From: Simon Davis
Sent: 17 December 2018 12:35
To: Lynnyrd Wolfe
Subject: FW: BN/52/18/DOC Lake Lane Barnham, Discharge of Planning Conditions.
Attachments: 2015-D1042-002F Engineering Layout.pdf

From: Nicholas Lack [REDACTED]
Sent: 07 December 2018 10:44
To: Simon Davis
Subject: BN/52/18/DOC Lake Lane Barnham, Discharge of Planning Conditions.

From: Mark Akmenkalns [REDACTED]
Sent: 07 December 2018 09:38
To: Laura Gibbons
Cc: David West; Nicholas Lack
Subject: D1042 - BN/52/18 - LAKE LANE, BARNHAM - RGPD Response 07-12-18

ARUN DISTRICT COUNCIL BN5218DOC

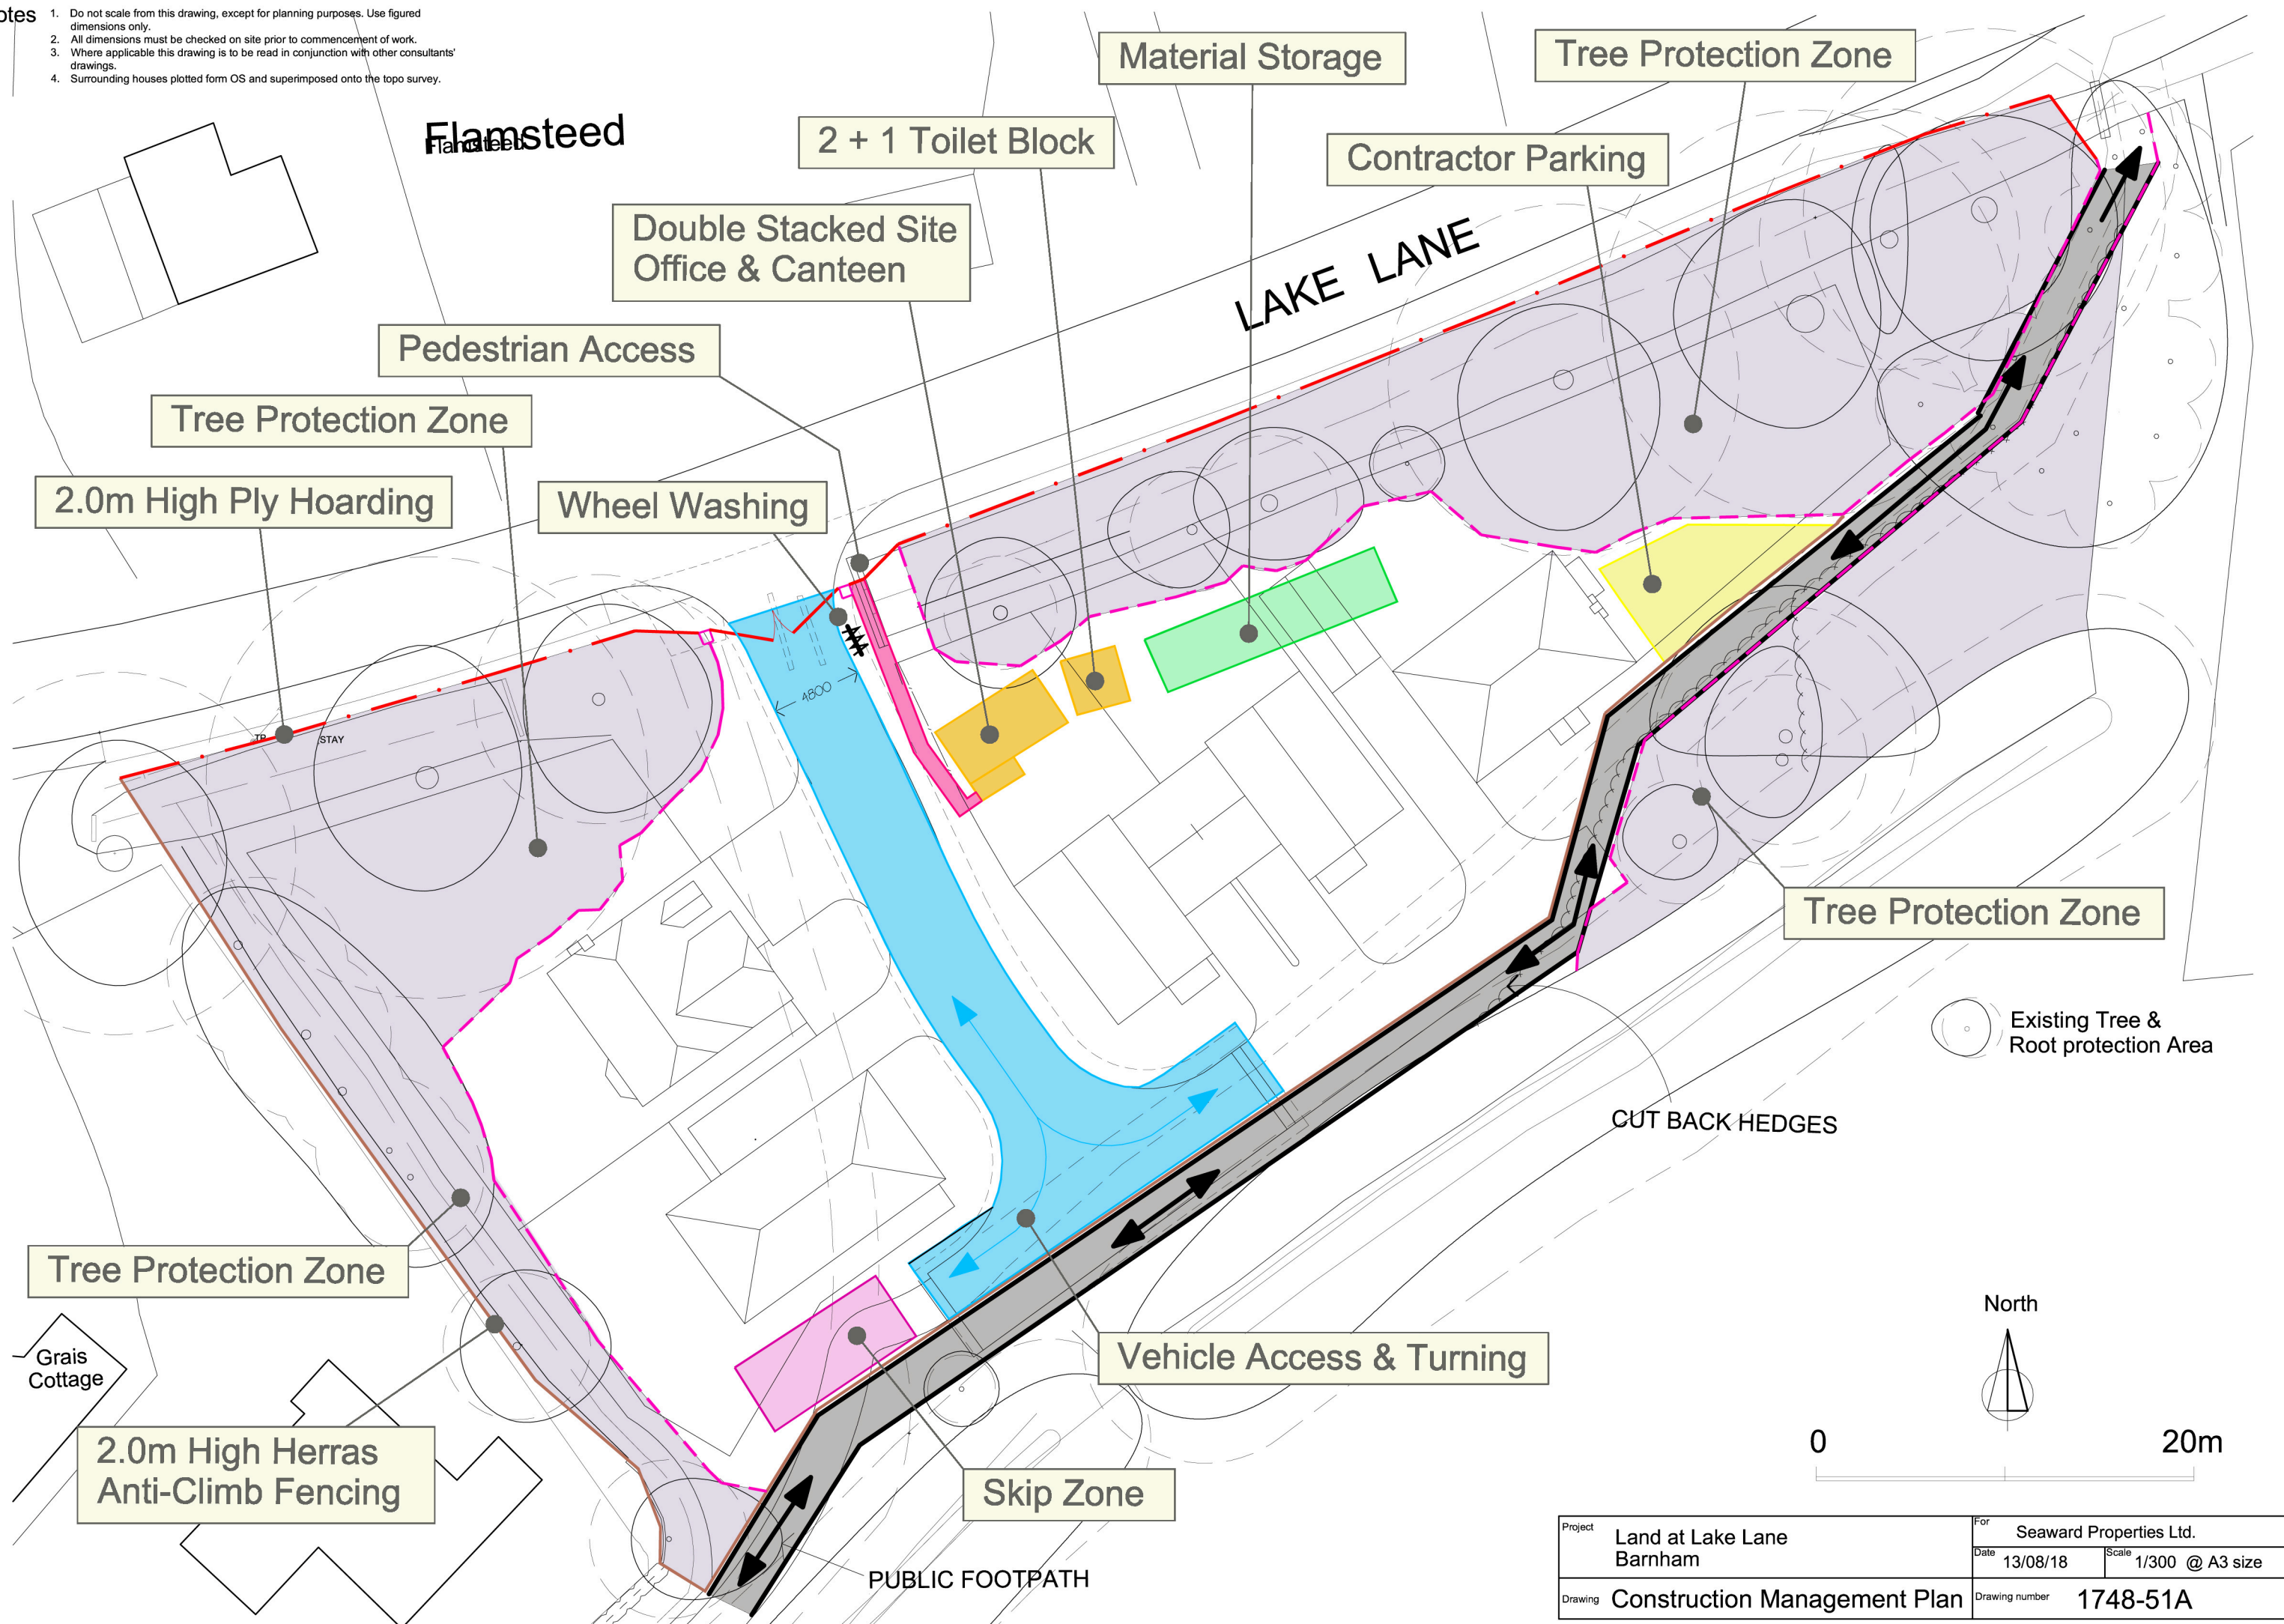
As discussed the risk of the permeable pavement 'exceedance run-off' flowing on to the Public Highway is negligible, however your preference is to safeguard this eventually. Therefore we attach the updated drawing 002F to cater for this.

1. The design head will result in water at CL to achieve 2l/s. I would prefer to see some freeboard. See comment 3 below regarding sub base depth.
2. Had a chat with Paul regarding this and he stated that WSCC policy is to now require consent for proposed discharge rates. Due to the age of the consent it would be inappropriate to update the wording. Therefore, you will need another land drainage consent.
3. The construction detail specifies a minimum of 500mm depth of sub base. Please can you update this to say a minimum of 540mm sub base (i.e. to be in excess of maximum water depth).
4. Thank you for the letter, I accept this point is now closed out given this detail and the previous correspondence.

Further to the consultation response from ADC Engineer (Drainage & Coastal) Laura Gibbons, I attach a revised drawing 2015-D1042-002F which on behalf of the applicant I would request be substituted for the superceded 002E on the planning portal please.

1. The drainage strategy report was approved at planning stage with the 5l/sec flow rate being accepted (Following DEFRA guidance). This is an historic development and was fully approved in principle over 2 years ago and we are merely implementing the approved design. DEFRA guidance is outdated. 5l/s is a significant increase in flow from the existing runoff which is 1.4l/s, this in my opinion would result in flood risk being increased elsewhere. Please revise design for 2l/s outflow. We accept there is now a push to better adhere to greenfield rates and attach revised Mircodrainage calculations conforming to a 2l/sec flow restriction without need to increase the sub-base storage. The solid handling opening size is confirmed to be of the order of 63mm and so will not be a high blockage risk. I attach drawing 002 Rev F updated to clarify this change.
